CITY OF ALBUQUERQUE

RE: EL RANCHO GRANDE, UNIT 8A (M-09/D019B)
Engineers Certification for Release of Financial Guaranty
Engineers Stamp dated 08/06/2003
Engineers Certification dated 09/20/2004

Re: El Rancho Grande 8A
AMAFCA Field Visit

**Re: El Rancho Grande, Units 6,7 & 8 Drainage Report
Engineer's Stamp dated 9-4-01, (M9/D19B)**

CONCRETE RUNDOWN SECTION B-B

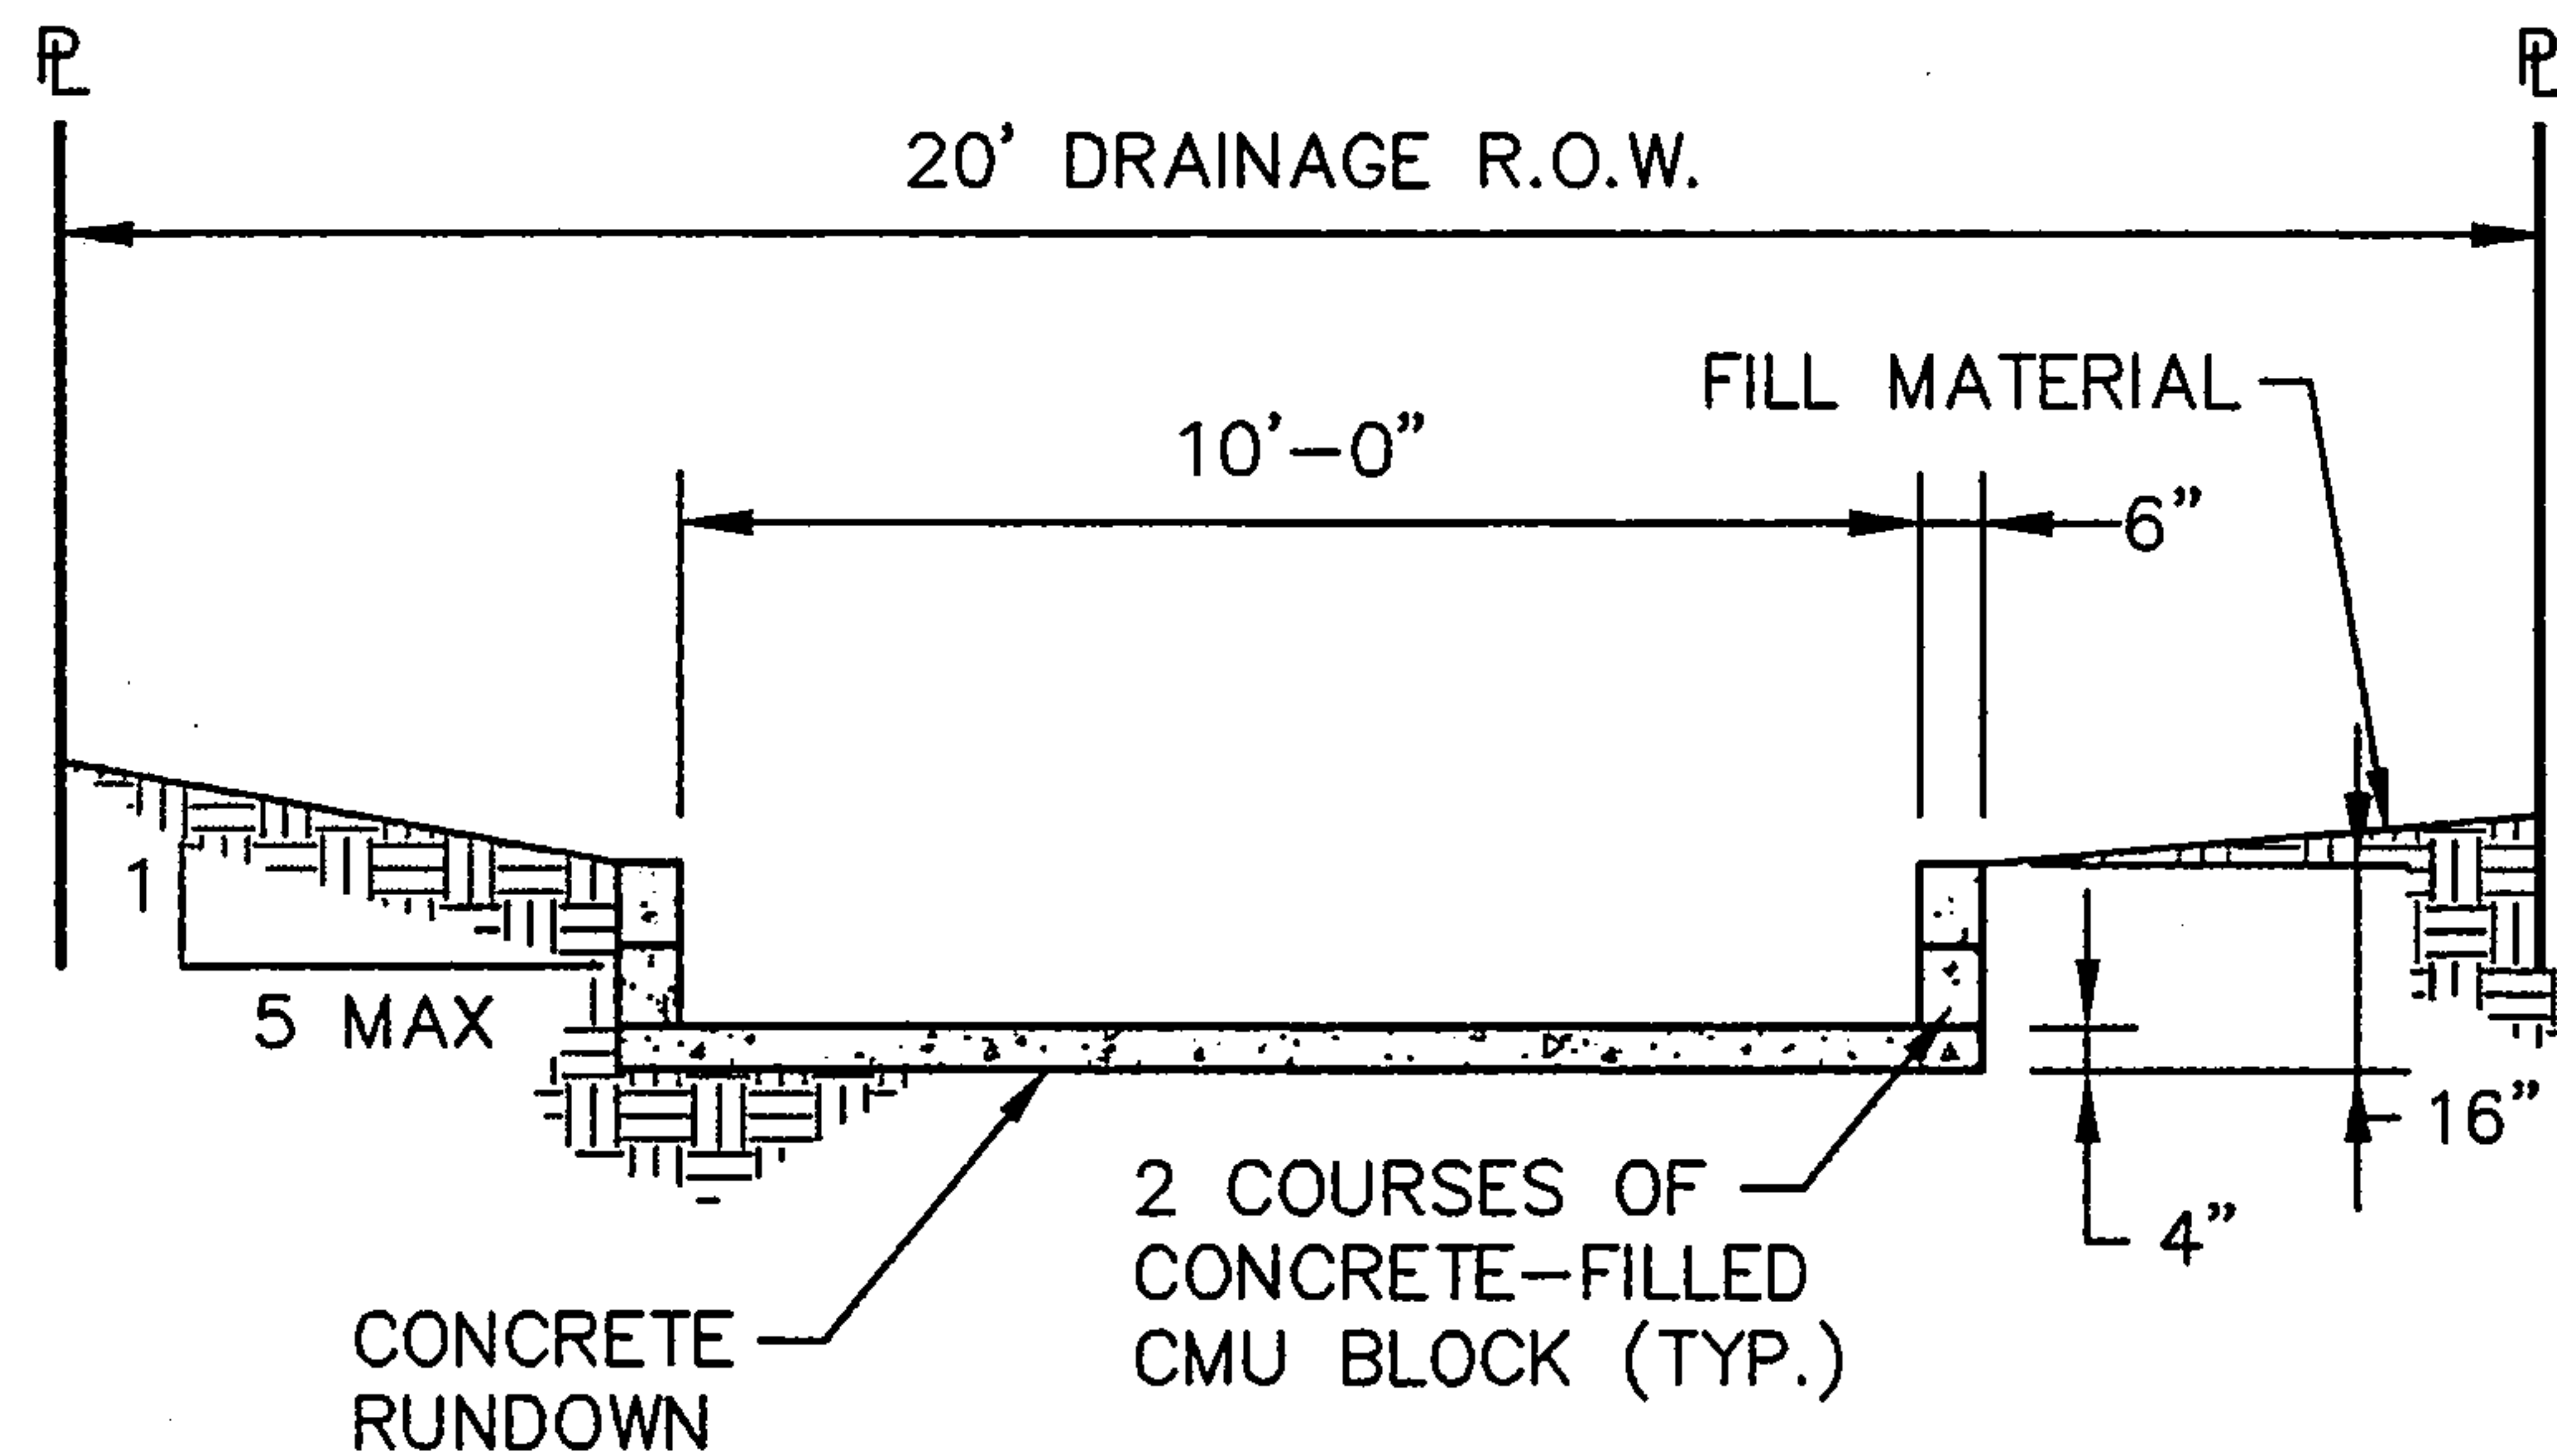
1. Rundown at the east end of De Anza Drive has been undermined and destroyed.
 - a. Concrete section undermined
 - b. Riprap section from the concrete section into the Snow Vista channel as been destroyed due to excessive undermining.

The conditions found above are disturbing in that the facility is less than a year old. Reviewing the project file, as-builts have not been forwarded to AMAFCA. It is unknown at this time if the rundown was built per the lines and grades shown on the plans.

Please review the design of the rundown to ensure that design was adequate for the location, soil conditions and flows anticipated.

Please submit to AMAFCA, by January 11, 2005, a letter report detailing the cause of the damage to the rundown, verification that the design of the rundown is adequate and a work plan to remediate the rundown
